**WELWYN HATFIELD BOROUGH COUNCIL
ASSISTANT DIRECTOR (PLANNING)**

Application No: 6/2024/0389/HOUSE
Location: 14 Gorseway Hatfield AL10 9GS
Proposal: Erection of a single storey rear/side extension and front porch
Officer: Mrs Kerrie Charles

6/2024/0389/HOUSE

Drawing No: 5899-P01 Revision: **F**

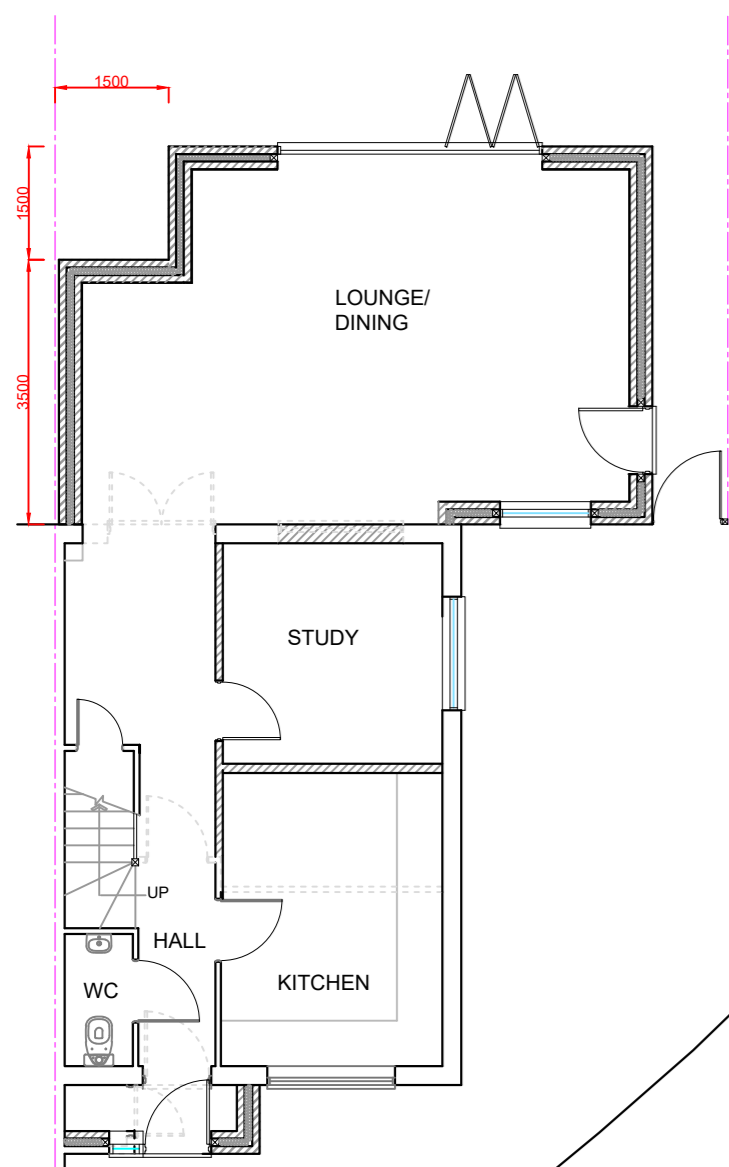
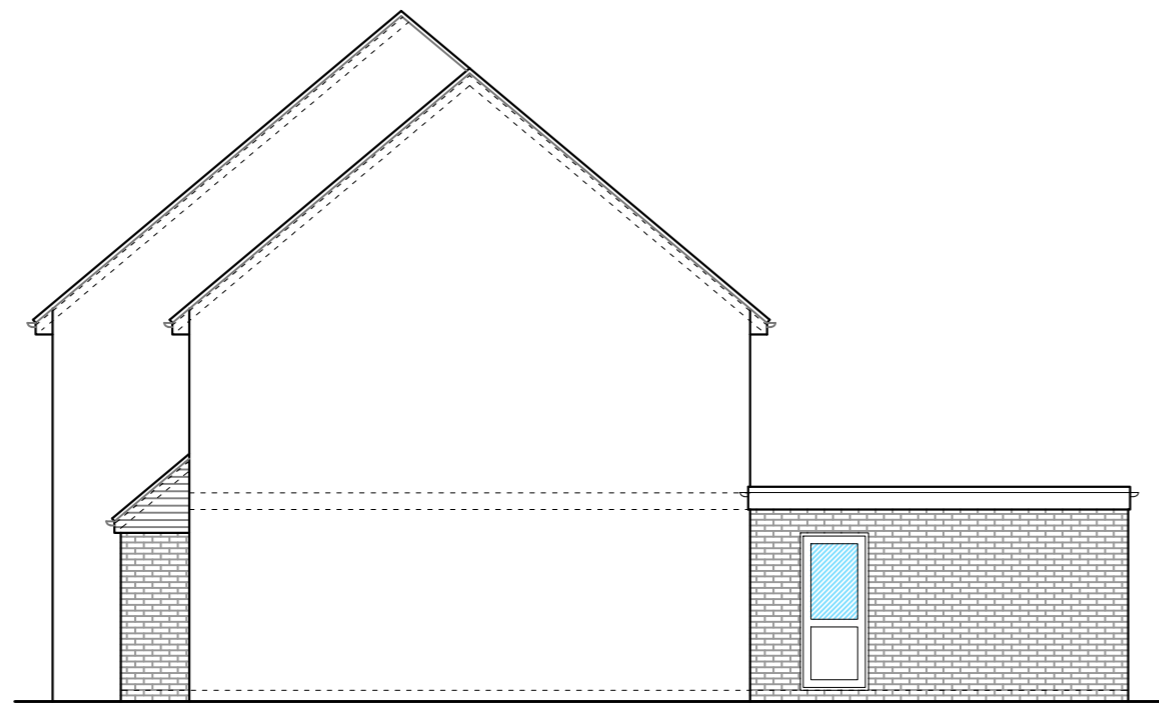
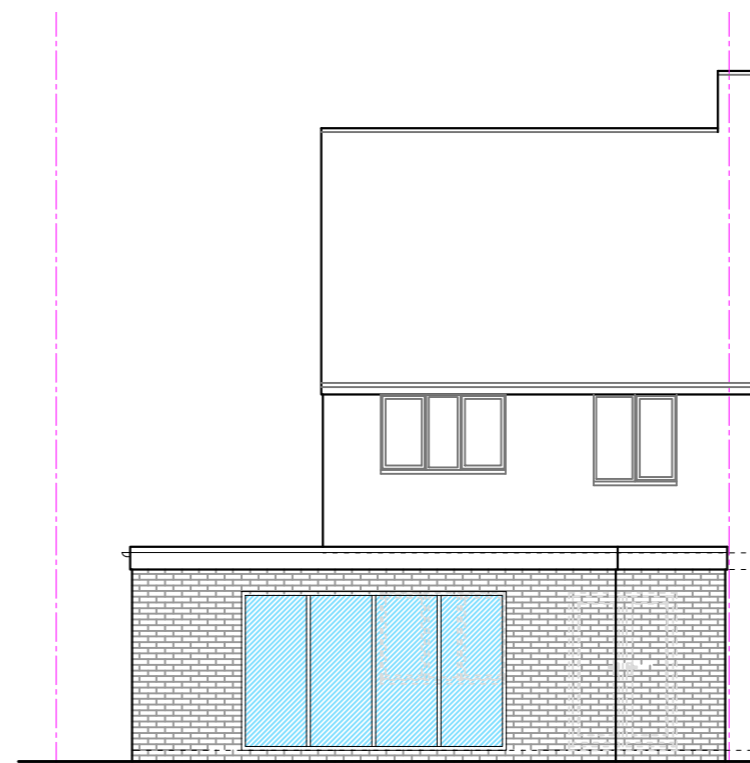
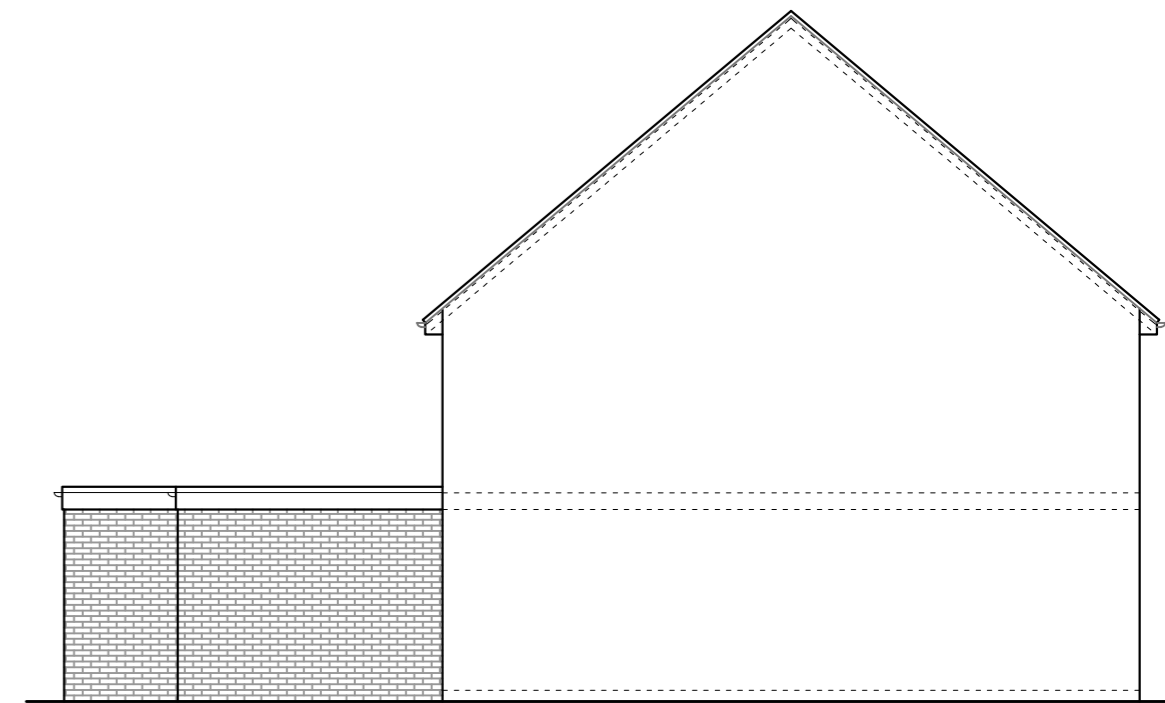
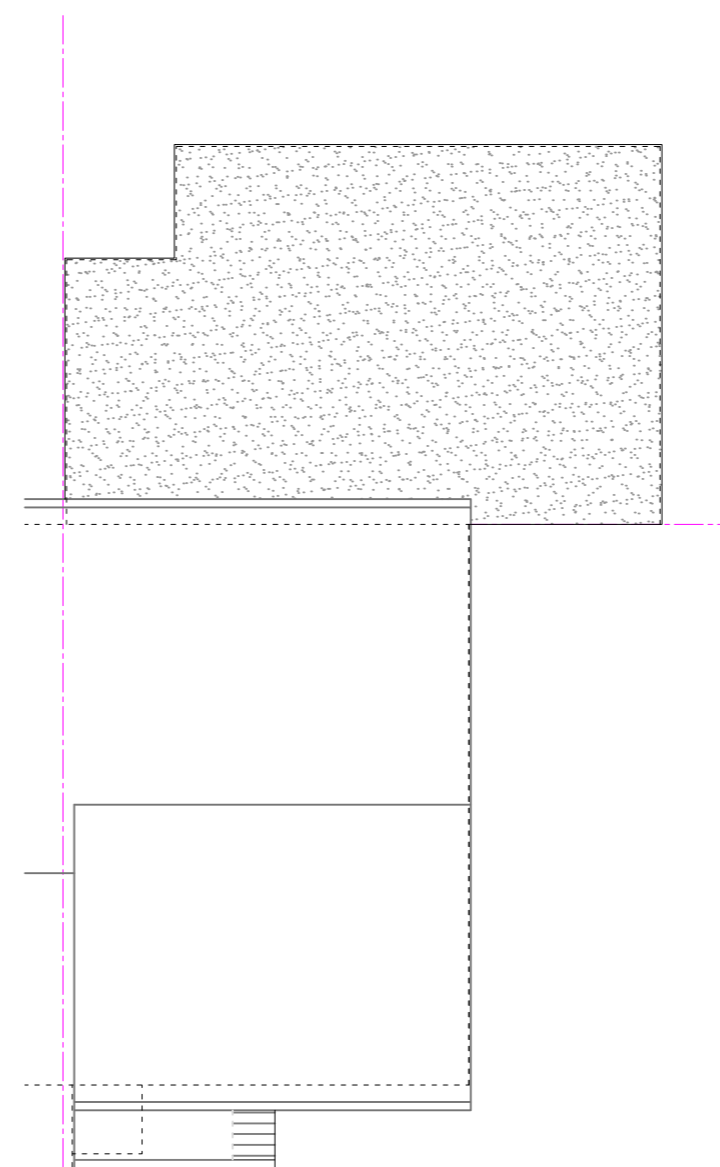
The proposed porch and rear/side extension would be visible within the streetscene due to its position adjacent to the road. However, taking into consideration the proposed scale of the development, subject to a condition requiring matching materials to be used, it is not considered that there would be any harmful impact to the character of the streetscene and surrounding area.

No neighbour representations have been received. Taking into consideration the proposed size of the rear extension and front porch, the living conditions of the adjoining occupiers would be maintained to an acceptable level in accordance with Local Plan Policy SADM11, the Supplementary Design Guidance 2005 and the NPPF.

The County Highways Authority objected to the development in regards to the proposed hardstanding. This has now been removed from the description of the development and does not form part of the proposal. Therefore, it is not considered that there would be any harms to highway safety arising as part of the proposal.
